**From:** [Robert Stark](#)  
**To:** [Simon Truong](#)  
**Cc:** [Amy Watson](#)  
**Subject:** RE: Clarification  
**Date:** Friday, 6 May 2016 10:20:11 AM  
**Attachments:** [image001.png](#)  
[image002.png](#)  
[image004.png](#)  
[image005.png](#)  
[Pages from 12023\\_31\\_Wheat\\_Road\\_DA\\_Landscape\\_Drawings.pdf](#)

**From:** [Simon.Truong@planning.nsw.gov.au](mailto:Simon.Truong@planning.nsw.gov.au) [<mailto:Simon.Truong@planning.nsw.gov.au>]  
**Sent:** Friday, 6 May 2016 10:04 AM  
**To:** Robert Stark  
**Cc:** [Amy.Watson@planning.nsw.gov.au](mailto:Amy.Watson@planning.nsw.gov.au)  
**Subject:** Clarification

Section A | Western Public Domain

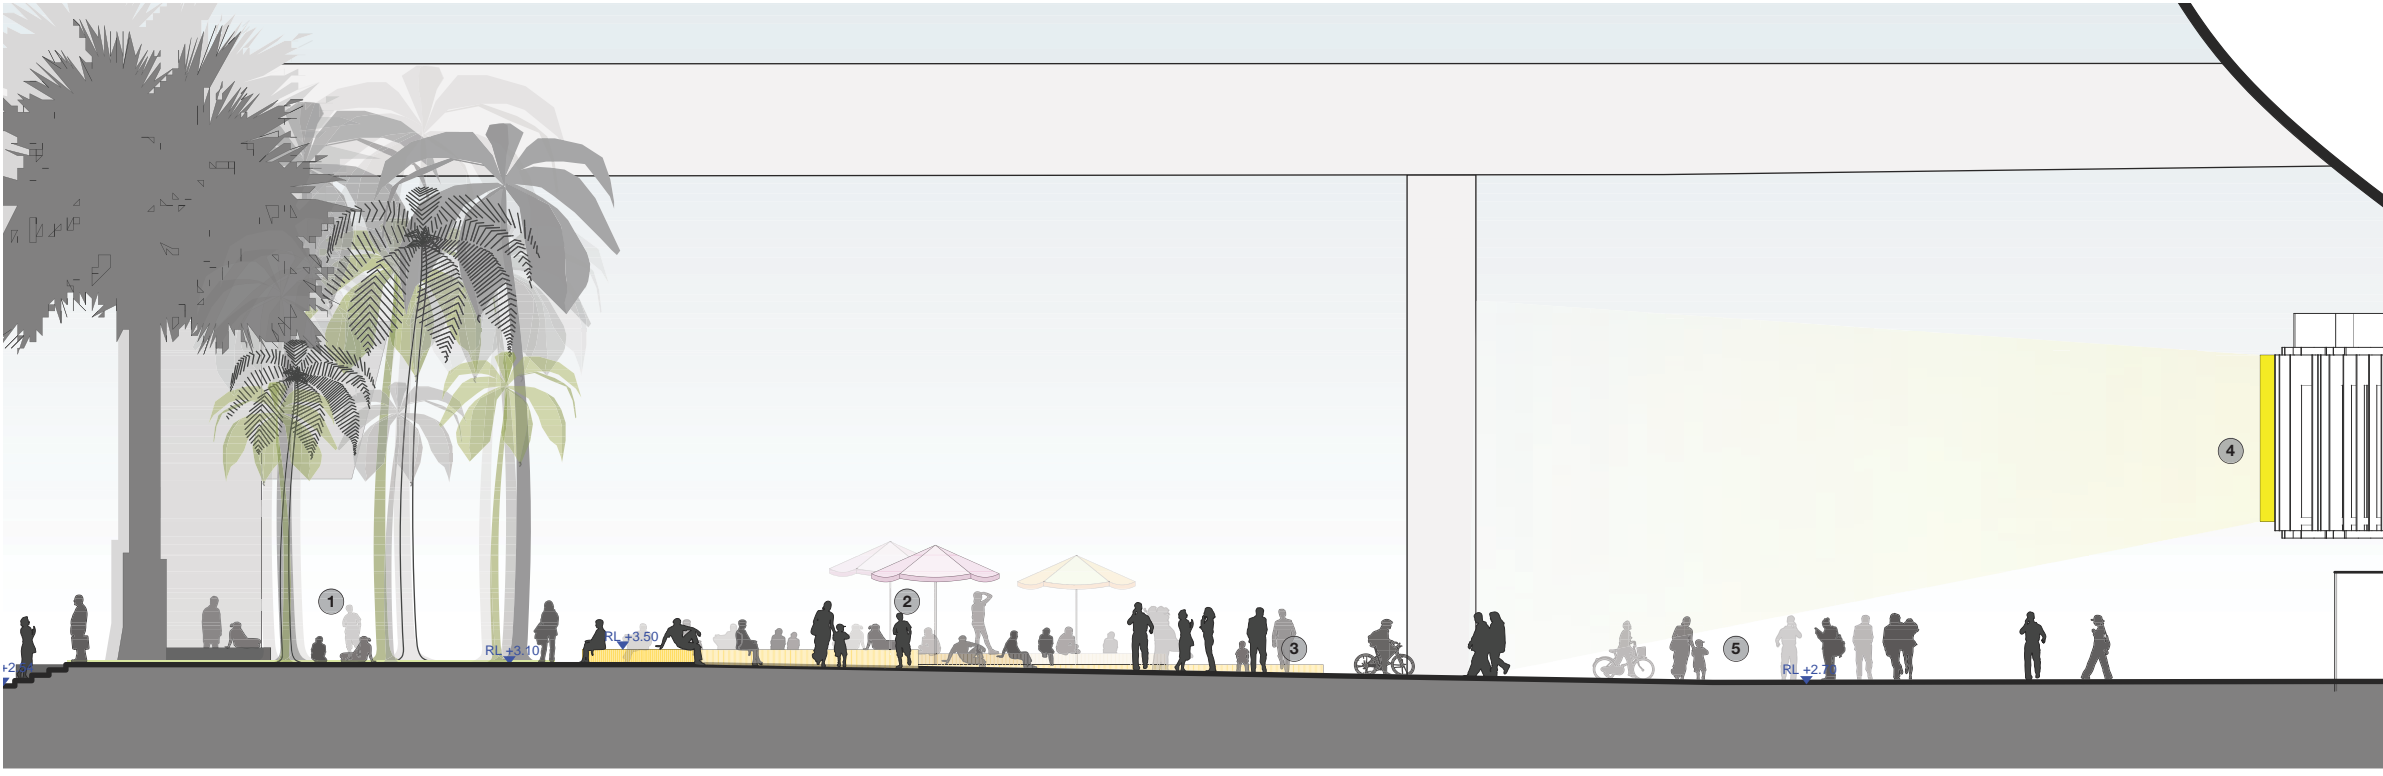
- the footpath dimensions at the eastern public domain as marked;
- number of palm trees to be relocated; and
- the type of plantation at the western public domain.

The plantation at the western public domain is palms – see attached.
